Address: 12, Temple Street, Huddersfield, HD3 3JG

Application number: 2026/92450	
What is the application for?:	Demolition of existing workshop and erection of detached dwelling
Address of the site or building:	Workshop between, 12 & 14/16, Temple Street, Lindley, Huddersfield, HD3 3JG
Postcode:	HD4 6HF

Revision	Description	Issued	Checked	Date
Client: Mr & Mrs McGowan				
Project: The Workshop, Temple Street, Lindley.				
Drawing: Scheme As Proposed				
Drawing Status: PLANNING				
Date: FEB 26	Scale @ A1: 1:100	Drawn by: AB		
Project No: 298	Drawing No: (0-) 02	Revision:

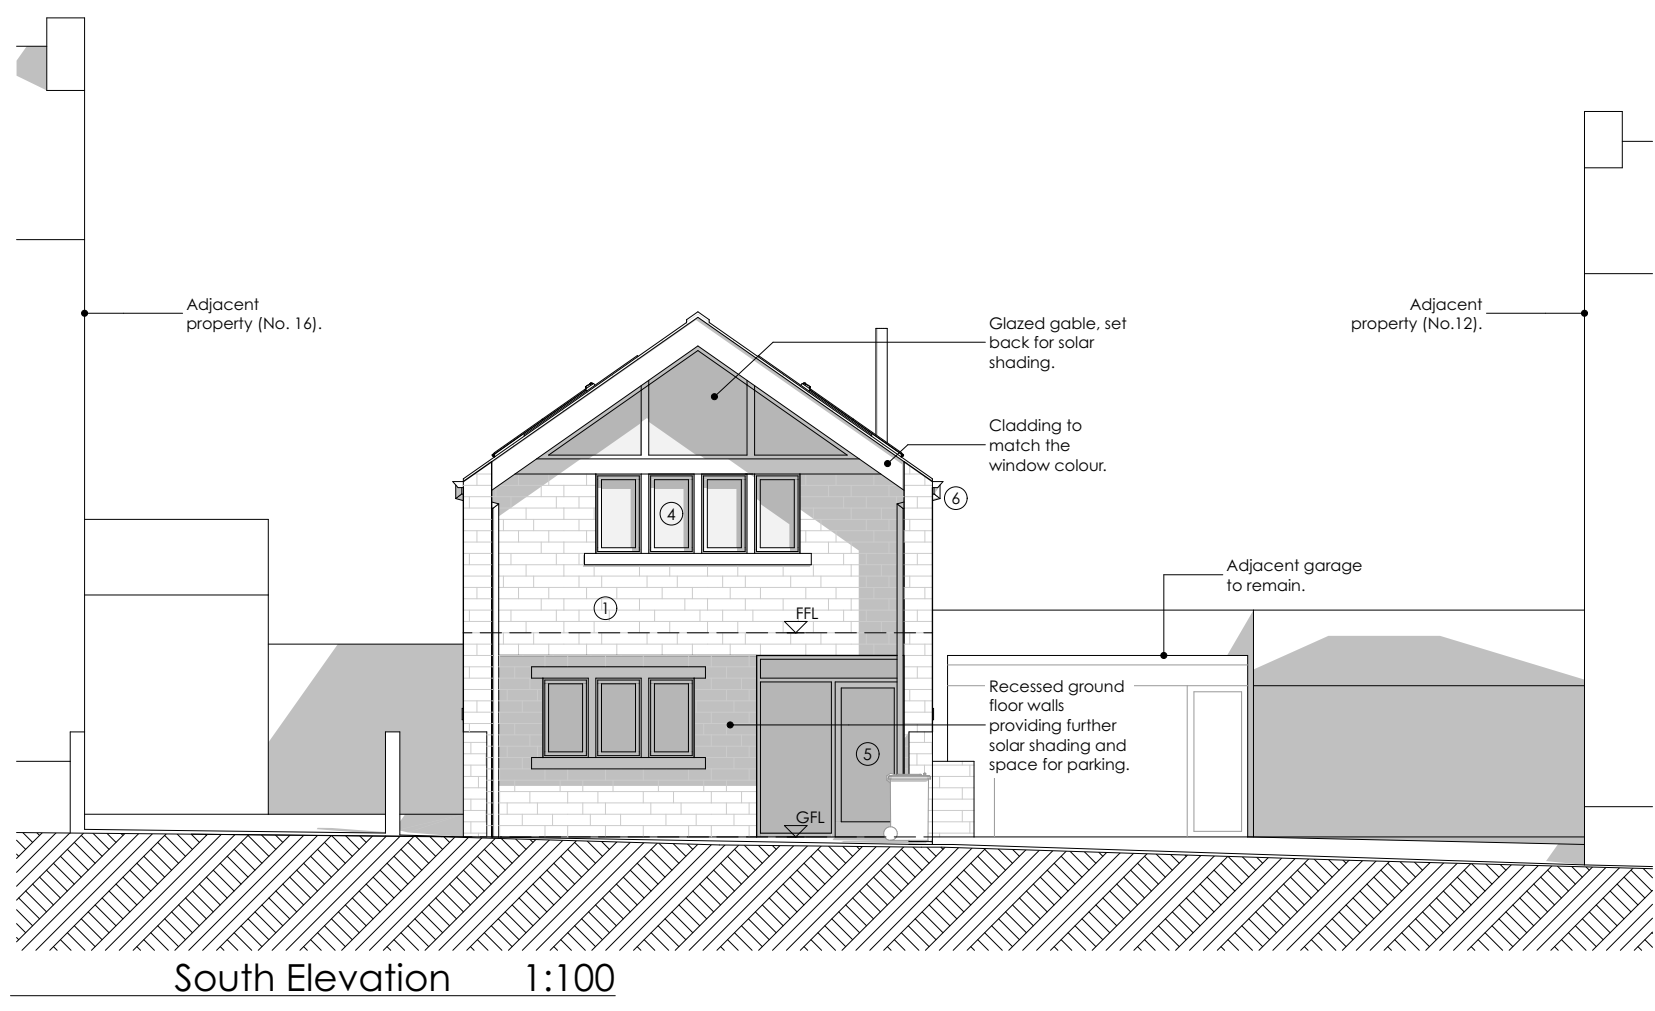
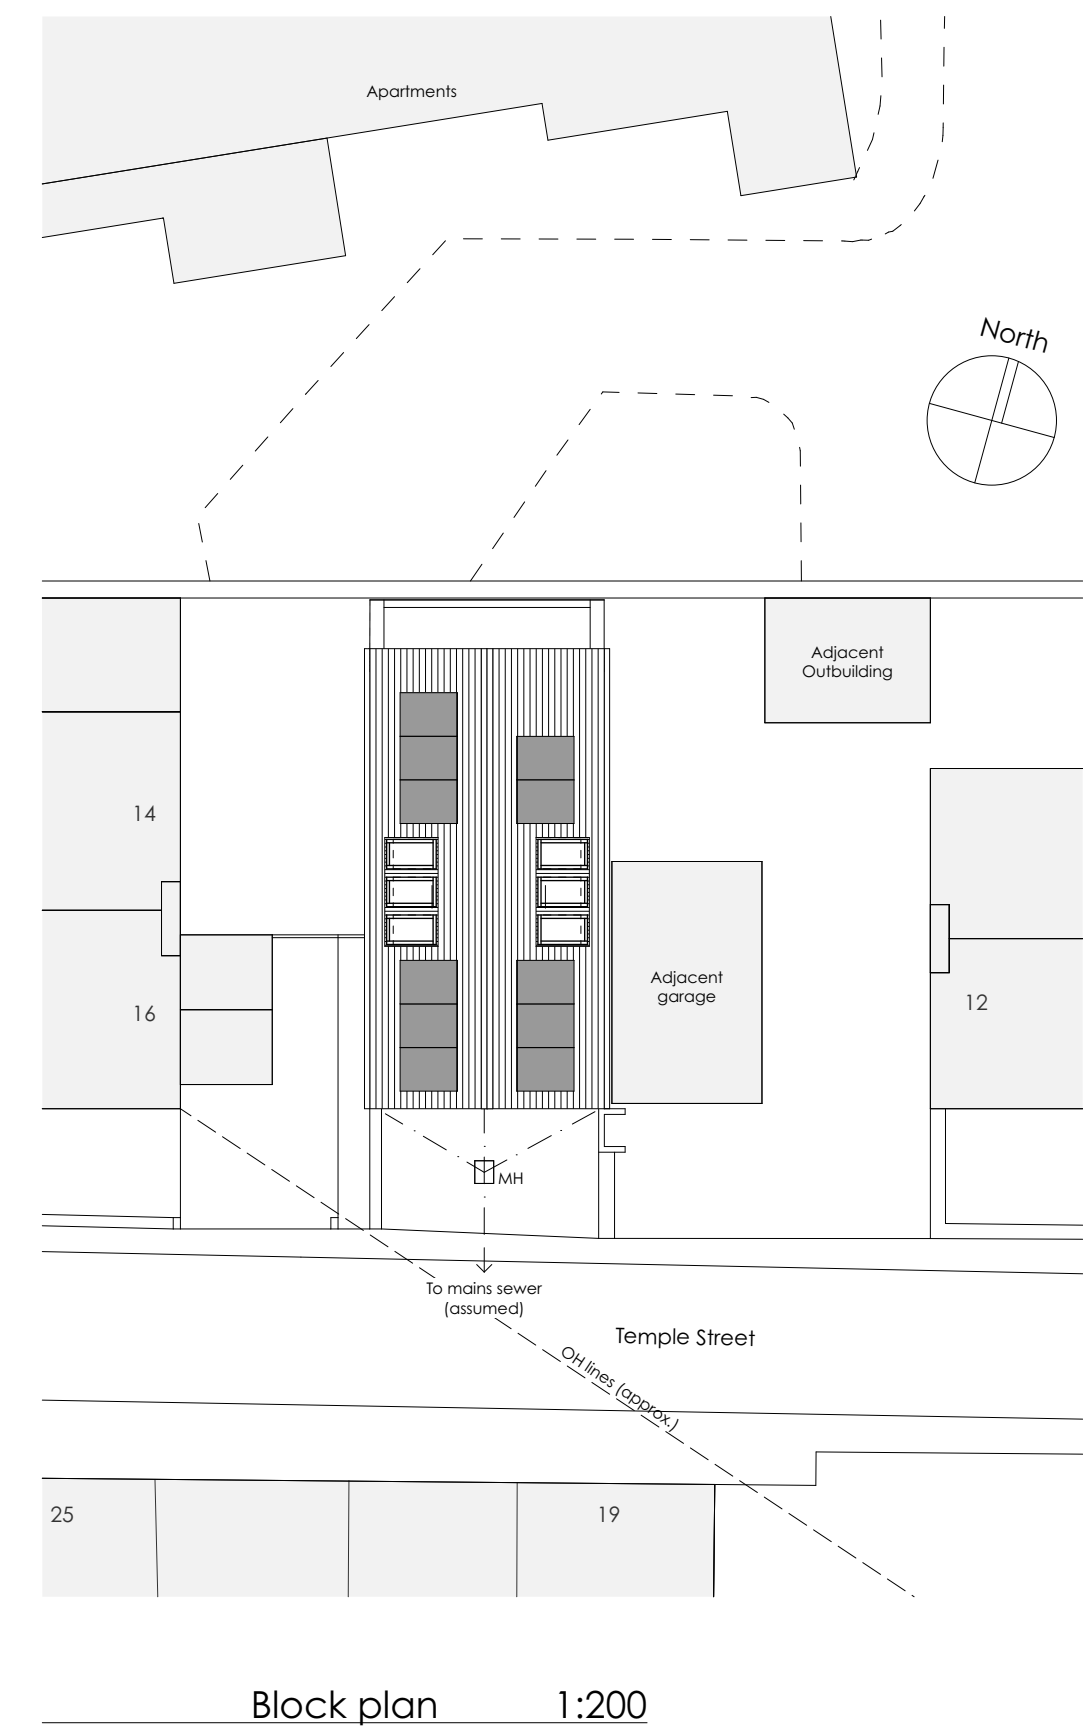
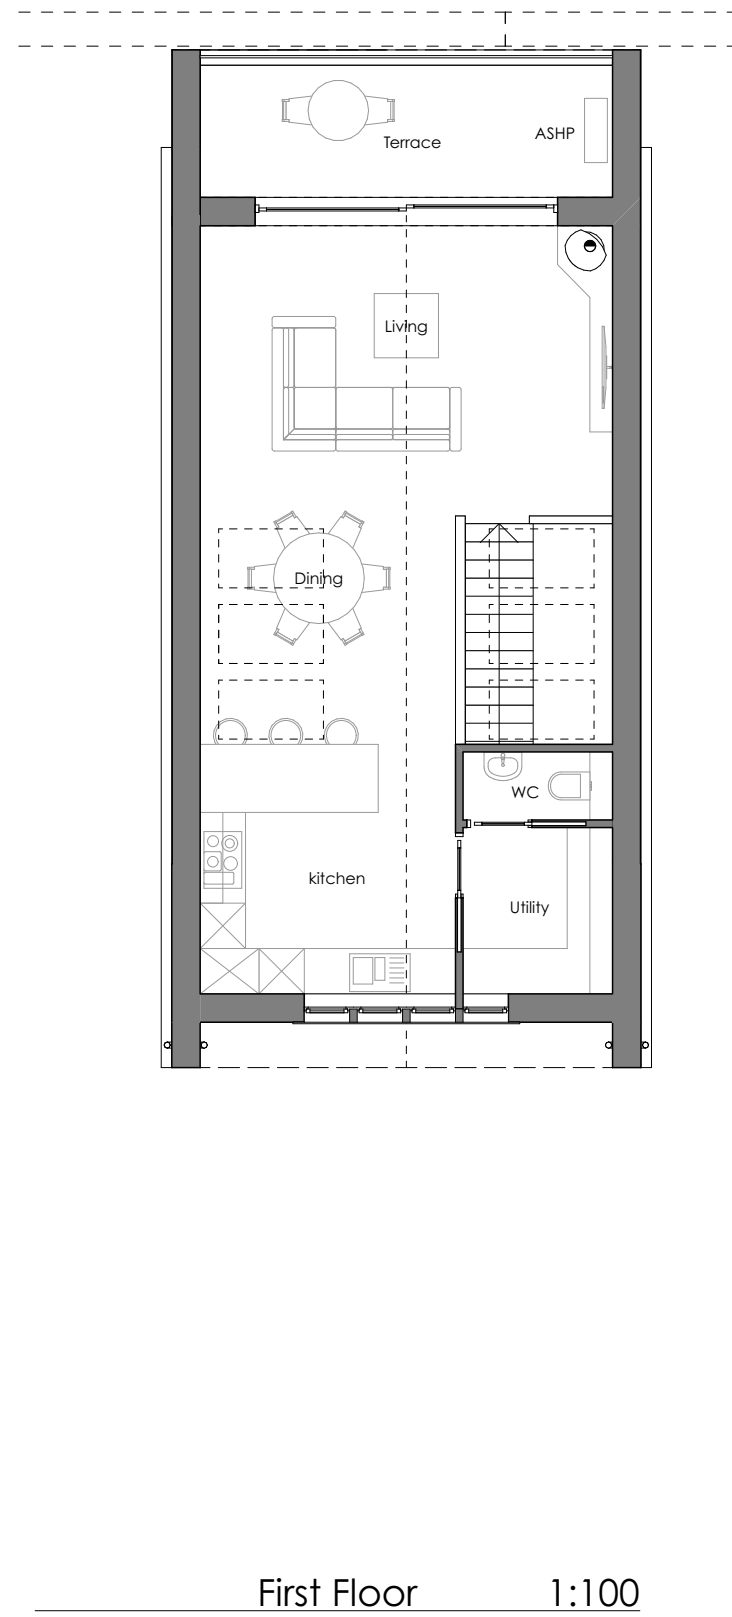
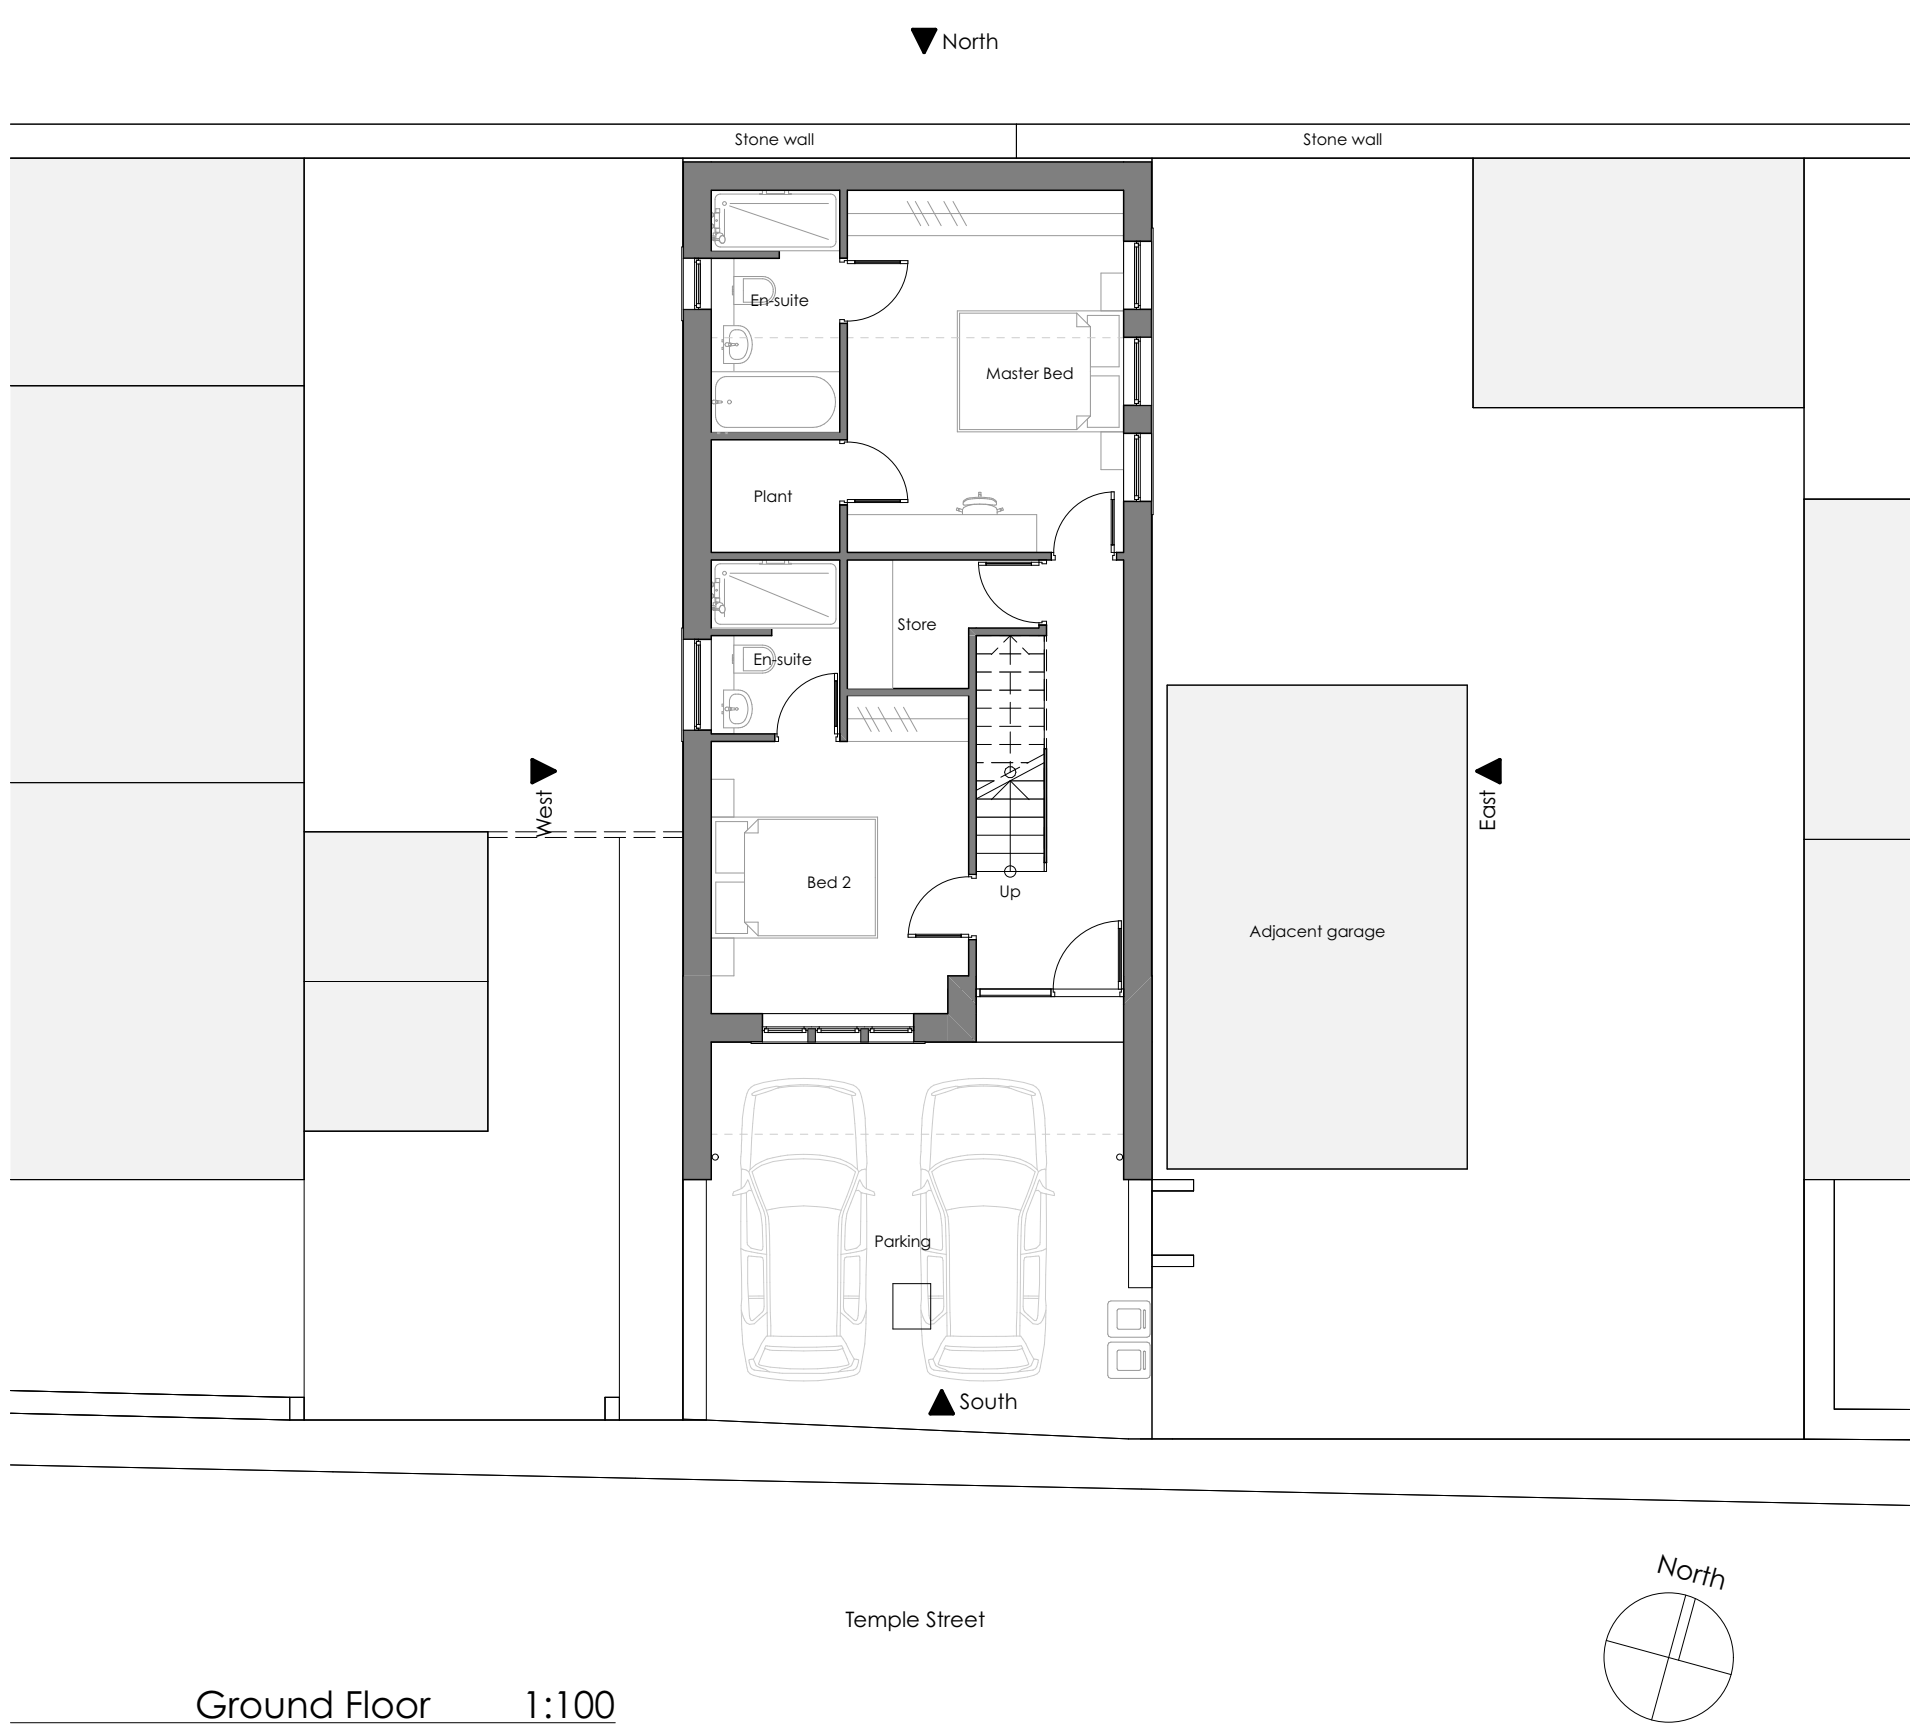
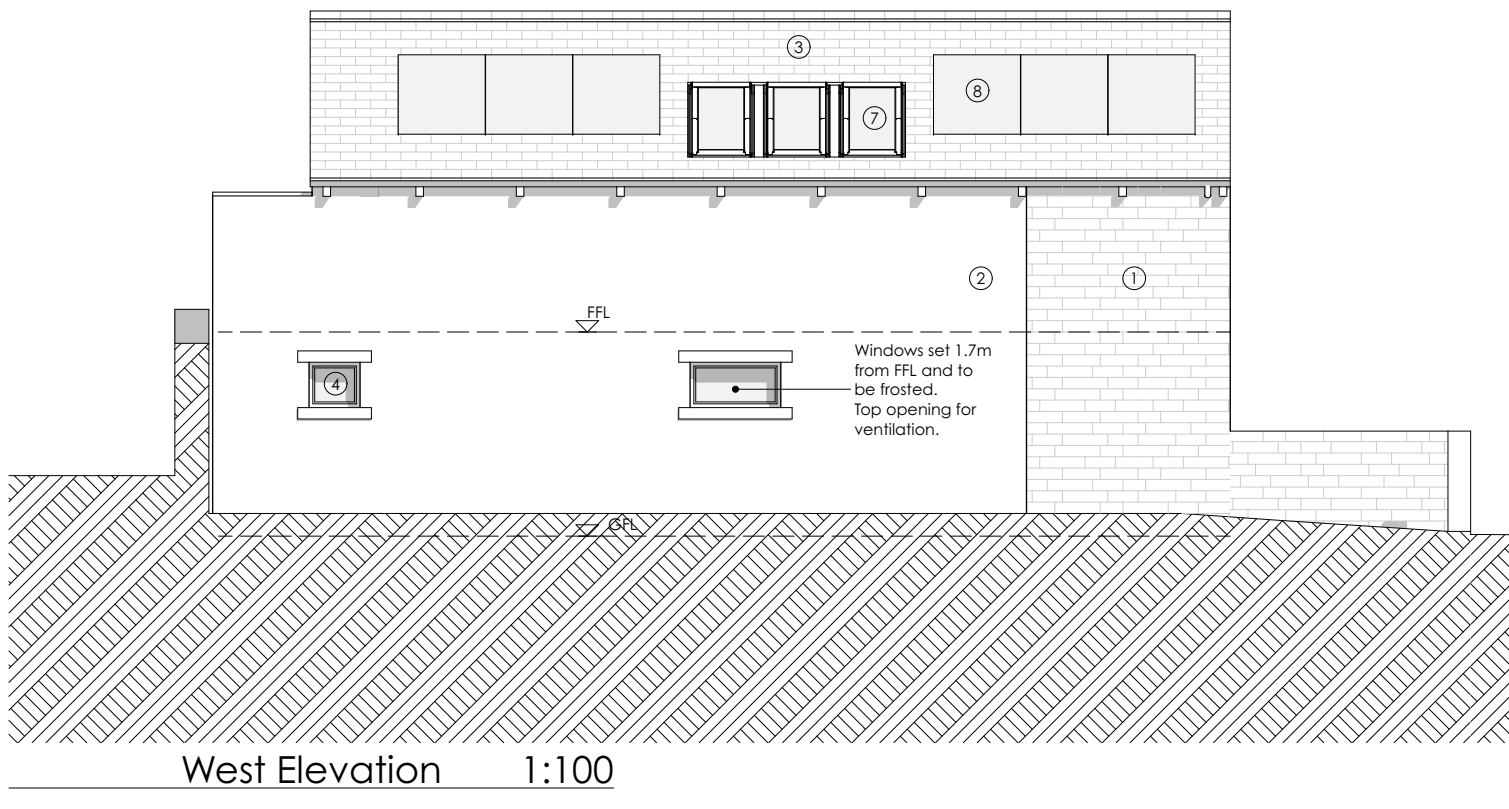
Type of comment: An objection	
Do you wish your comments to be published on the website anonymously?	No
To the windows on the east elevation, as these windows open onto our garden area. It will limit our plans on what we can do with that area of garden. For example if we want to move the garage backwards or build a summer house. Also concerned as this will be a bedroom it will impact how we can social use the space.
